**From:** Contact Centre (CRM) <contact@ribblevalley.gov.uk>  
**Sent:** 30 November 2022 12:29  
**To:** Planning  
**Subject:** Planning Application Comments - 3/2022/0947 FS-Case-468797472

**Planning Application Reference No.:** 3/2022/0947

**Address of Development:** Clitheroe cricket club  
Chatburn Road  
Clitheroe  
BB7 2AS

Clitheroe Cricket Club Site Plan

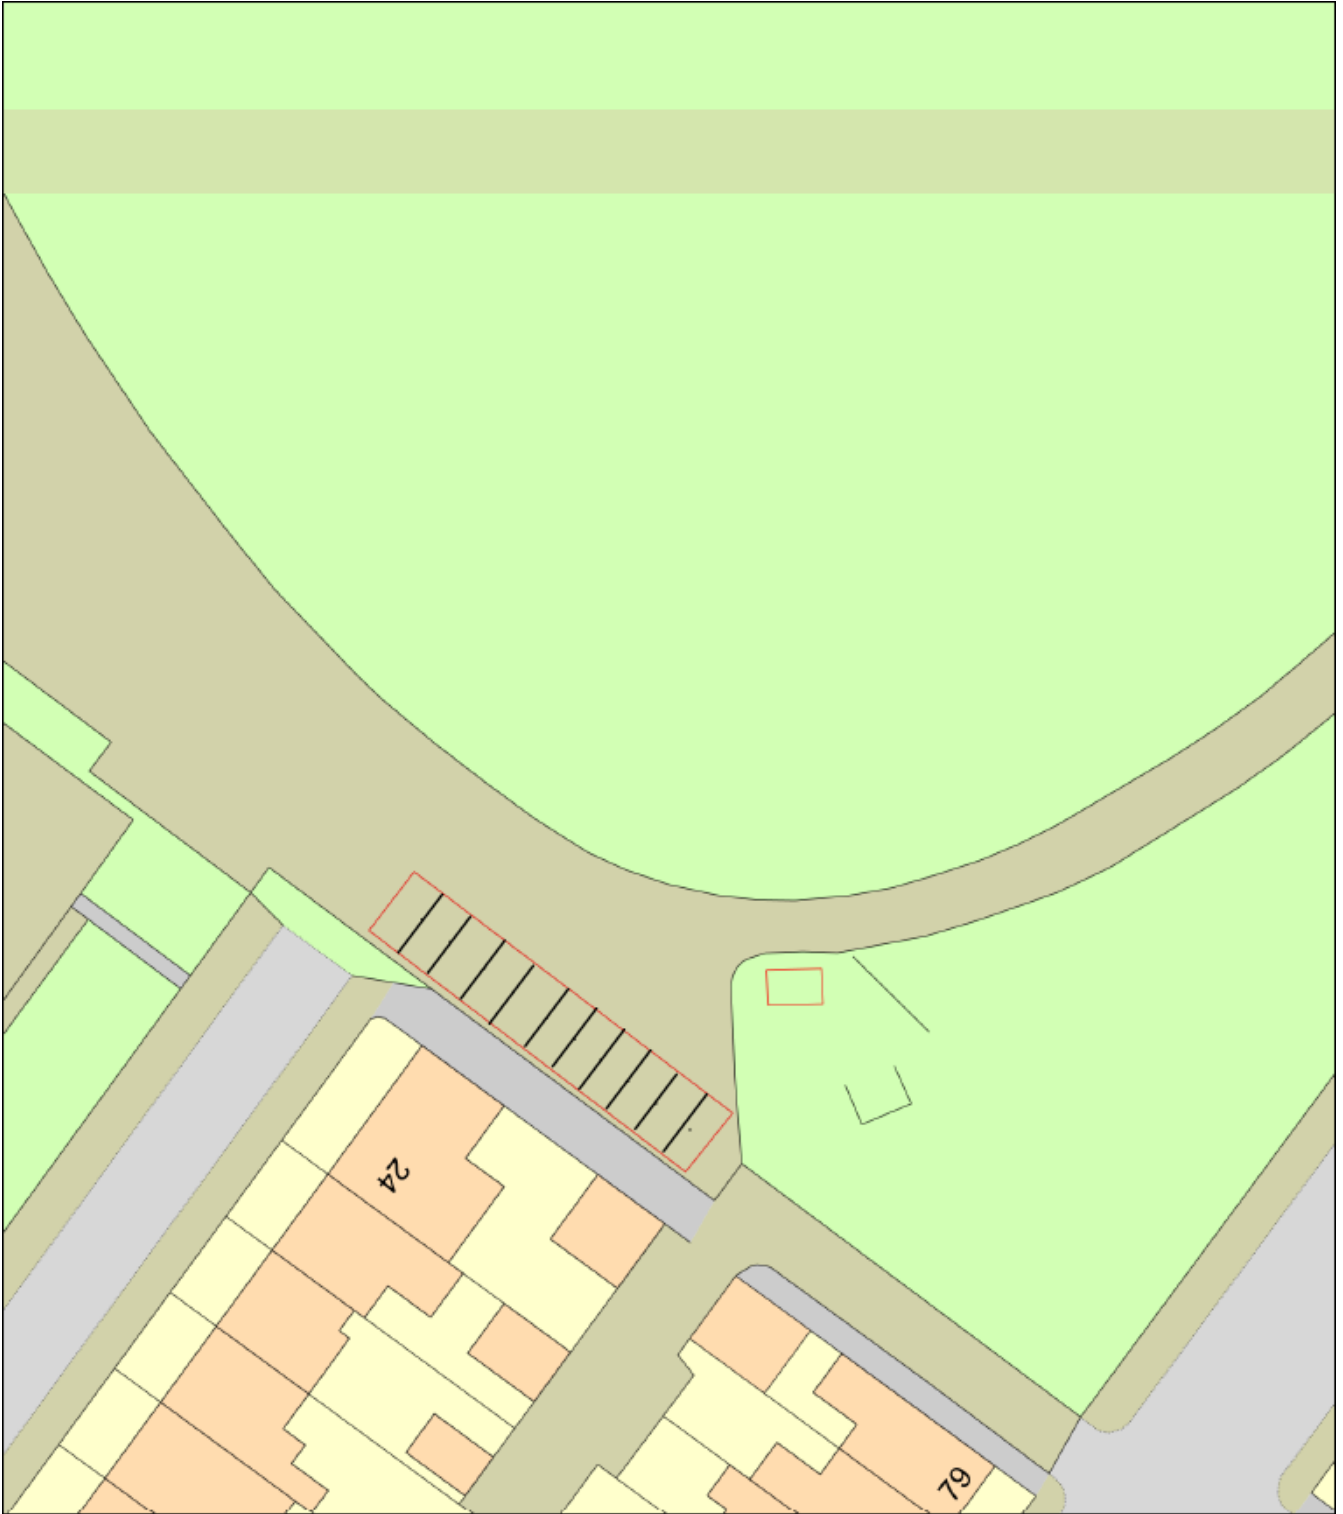
**Comments:** The proposed planning application states parking for 50 cars but the plan only shows parking spaces for 11 cars. The rest of the parking spaces are for use by the leisure centre which is located a little further on. Where are the additional car parking spaces?
